From: Maria Tomalova
Sent: 13 August 2019 12:04
To: Nicola Spencer
Subject: FW: Planning reference BR/180/19/PL - London Road, Bognor Regis.
Attachments: scan_paul.broggi_2019-08-12-15-19-36.pdf

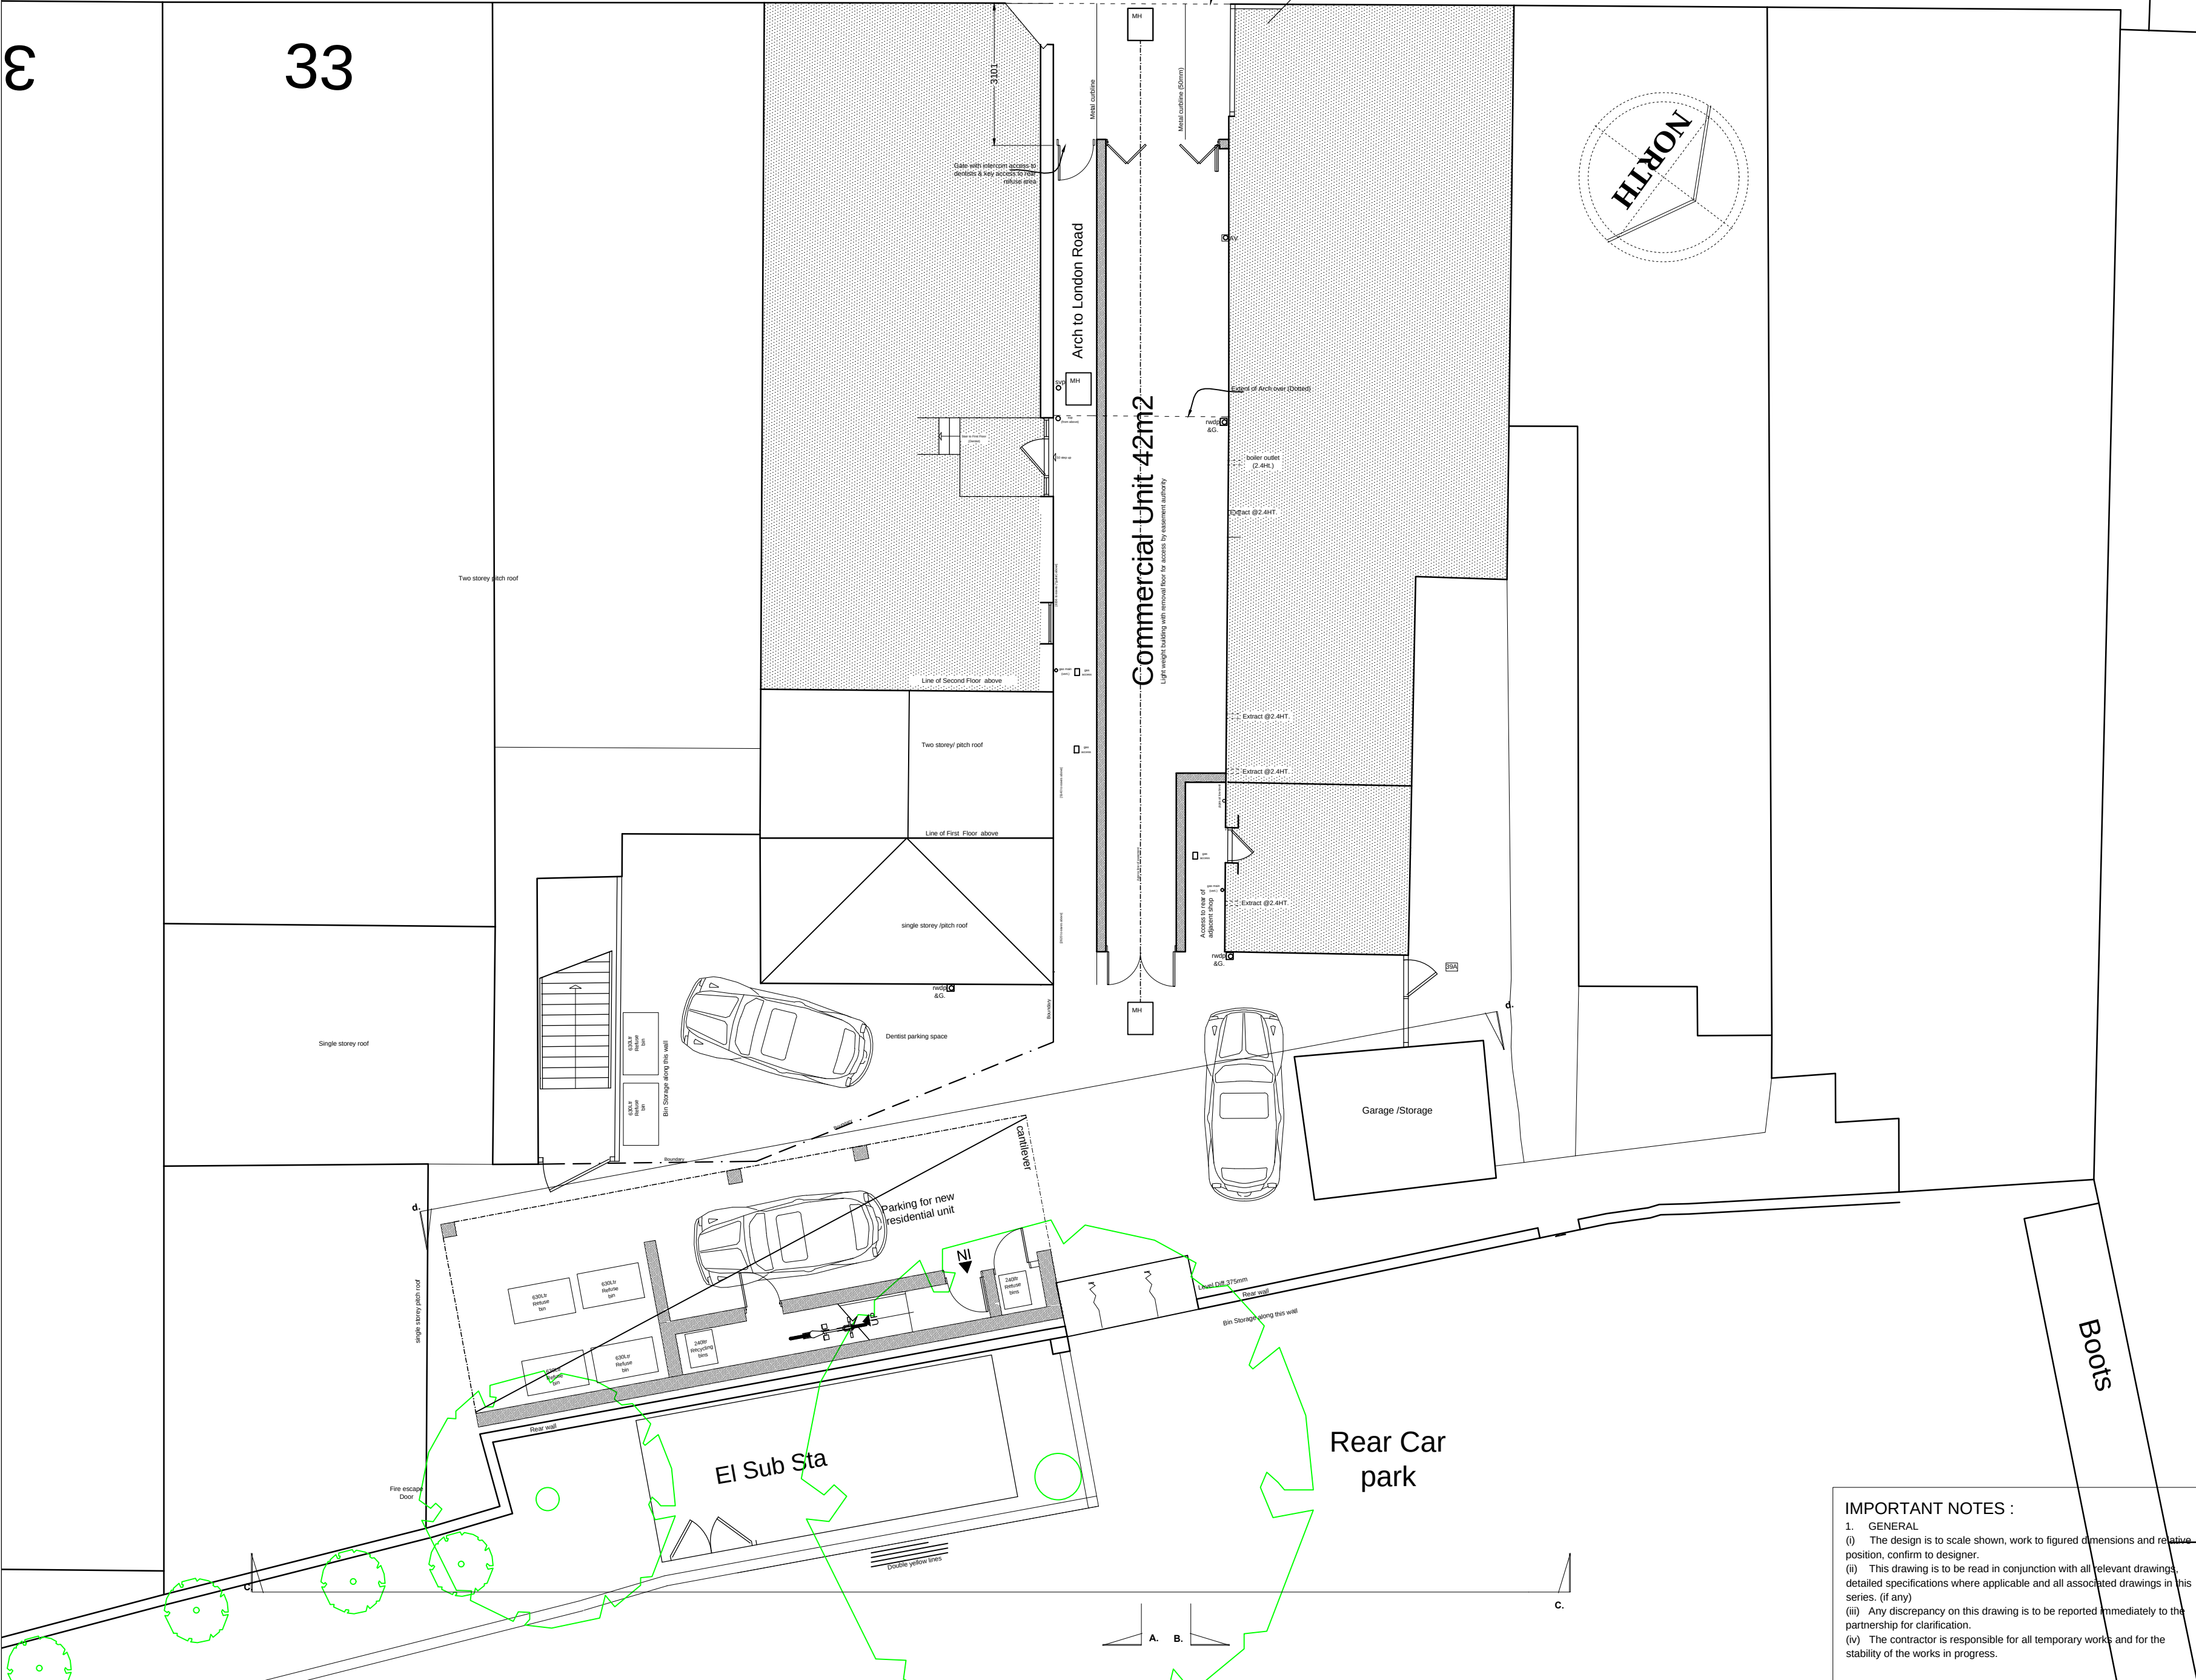
Further to my recent email I know that many premises along London Road have complicated rights of access to their properties and these could well be impacted by the proposed development. By example the Block plan and site plan drawing 637.06 REV A shows the residential building almost touching the adjacent structure to the rear of 33 London Road. The site plan drawing also notes a fire escape door in the structure to the rear of 33 London Road. I understand that this door forms part of a designated rear fire escape route for the adjacent Halifax Building Society at 31a London Road.
